CITY OF ALBUQUERQUE

February 6, 2020

Site: Mister Carwash at 98th St/Volcano Rd. – K08E004

Re: Drainage Ordinance (14-5-2-1) Violations for Erosion and Sediment Control

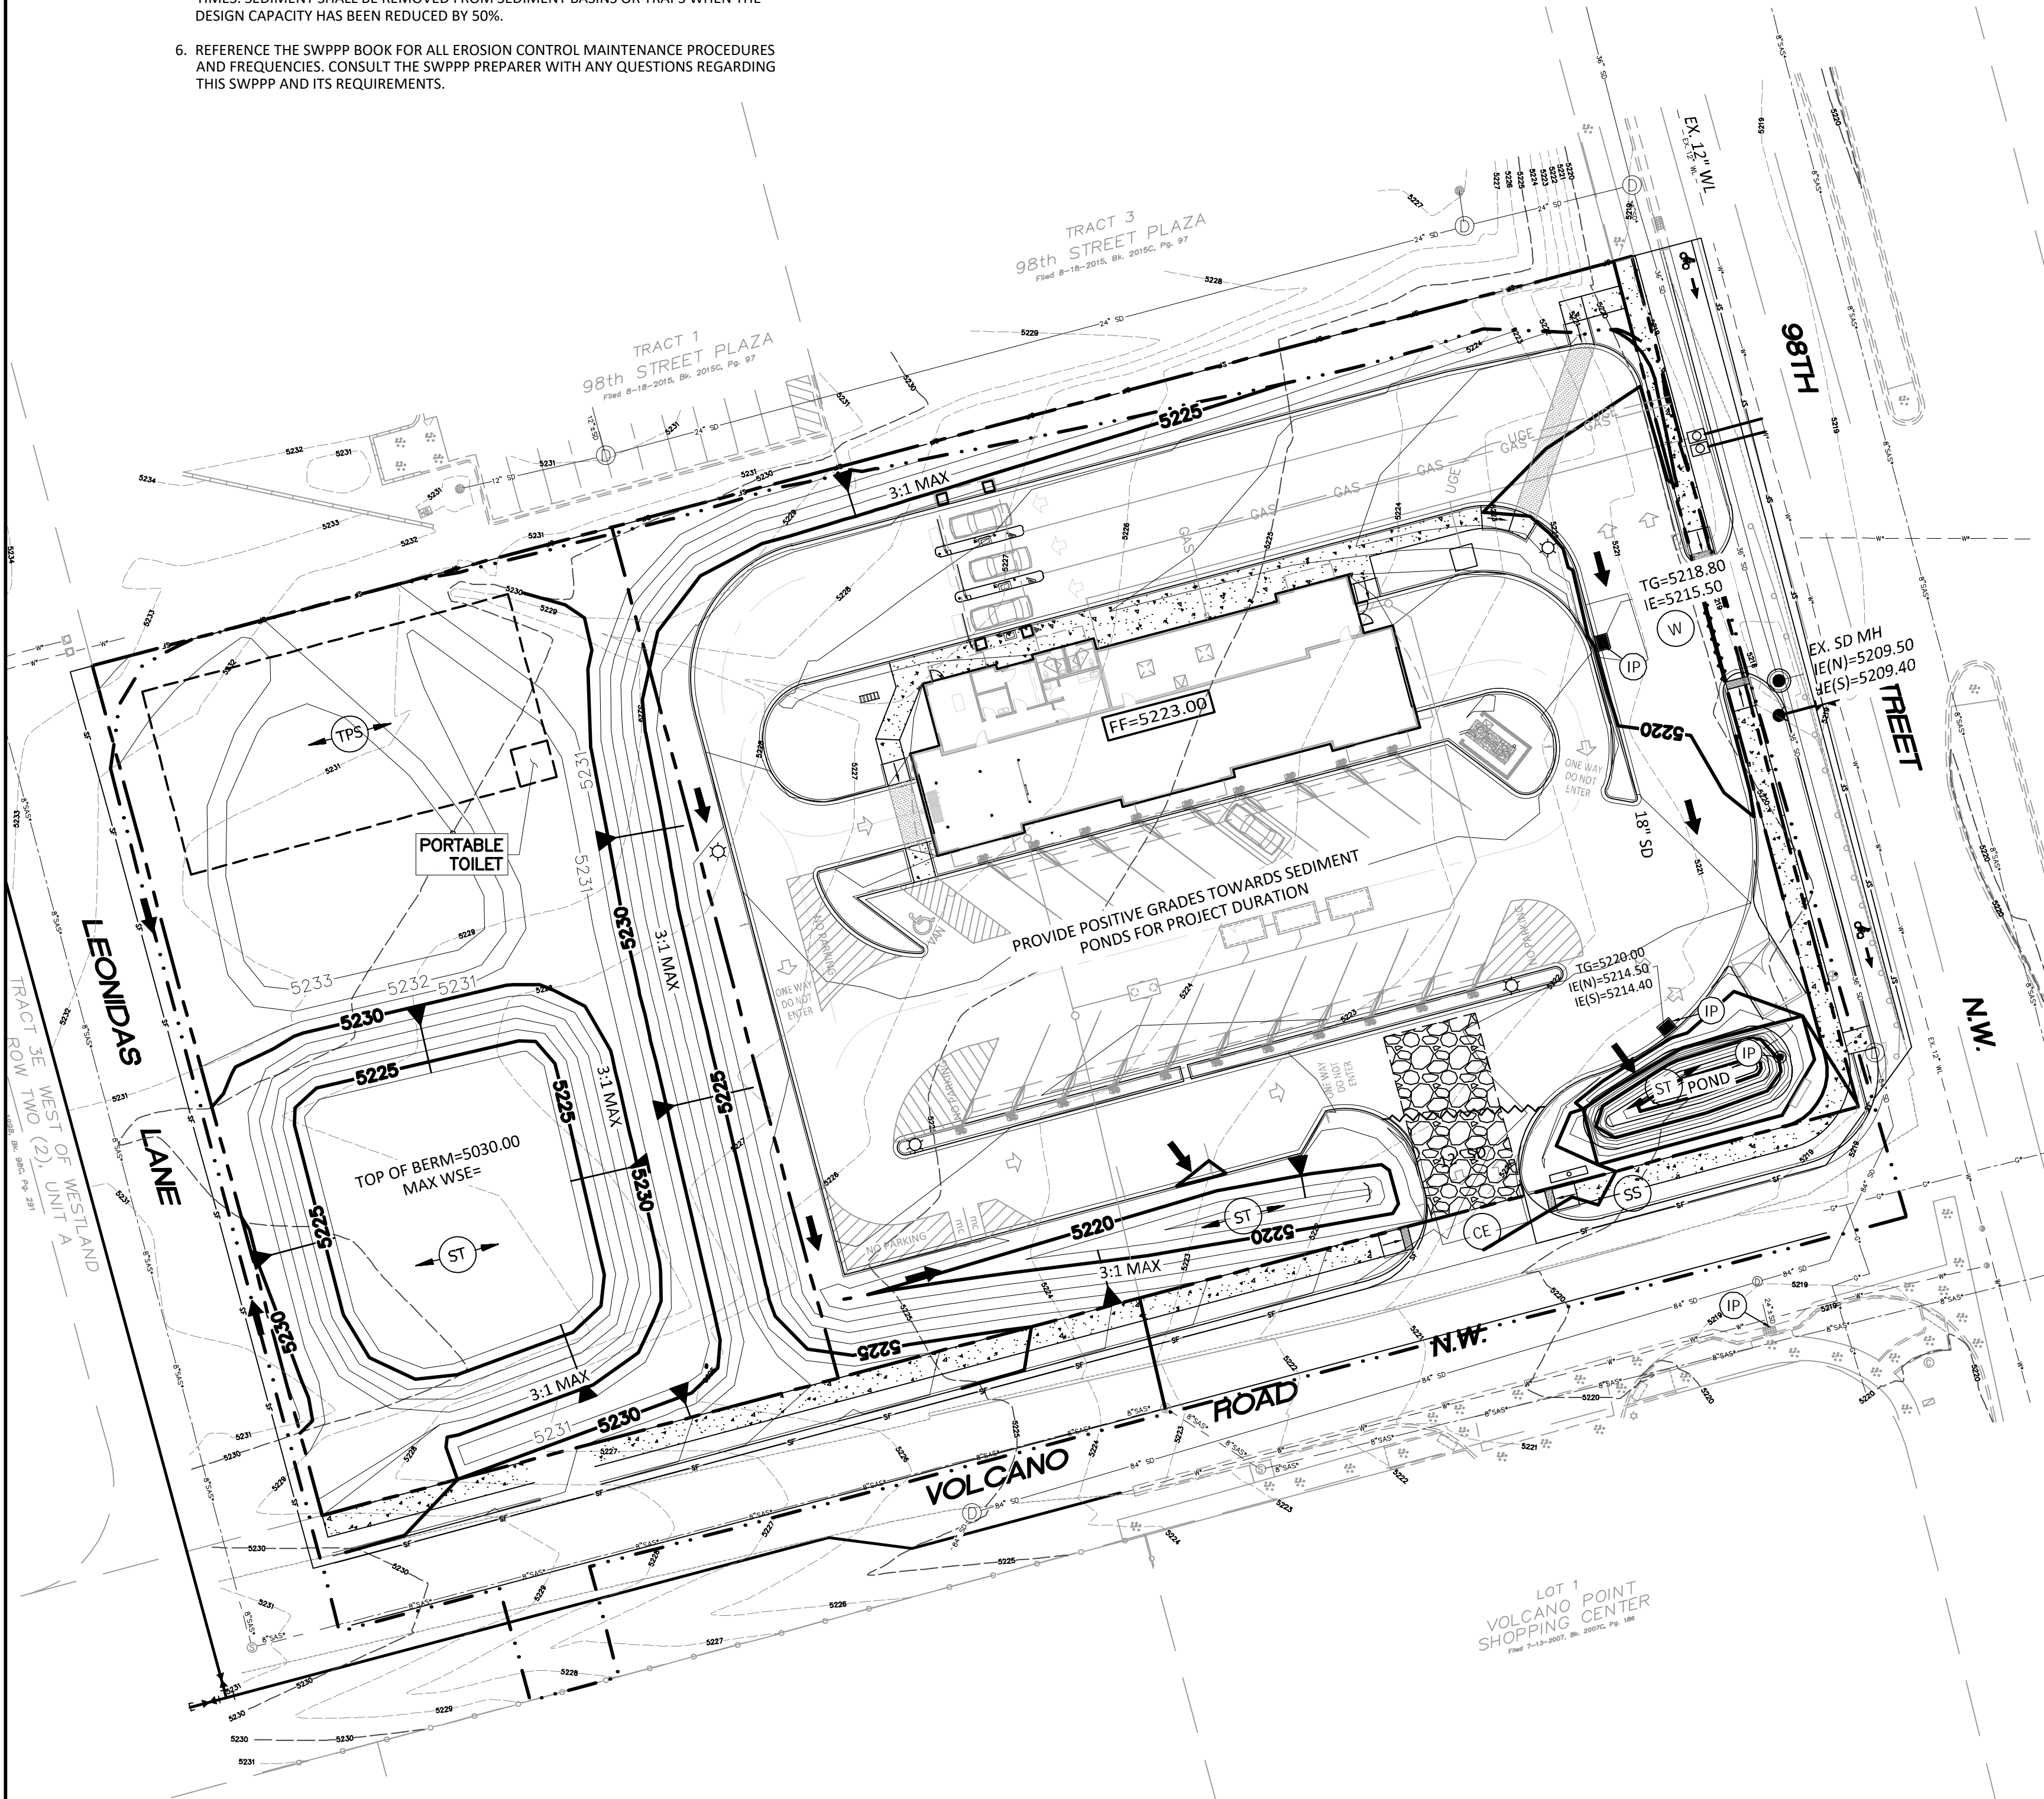
1. Construction started without properly posting the NPDES Permit
2. The Construction Entrance was missing
3. The Silt fence was not properly installed.

1. Post NPDES Permit on perimeter of site.
2. Install BMPs per the approved ESC Plan.
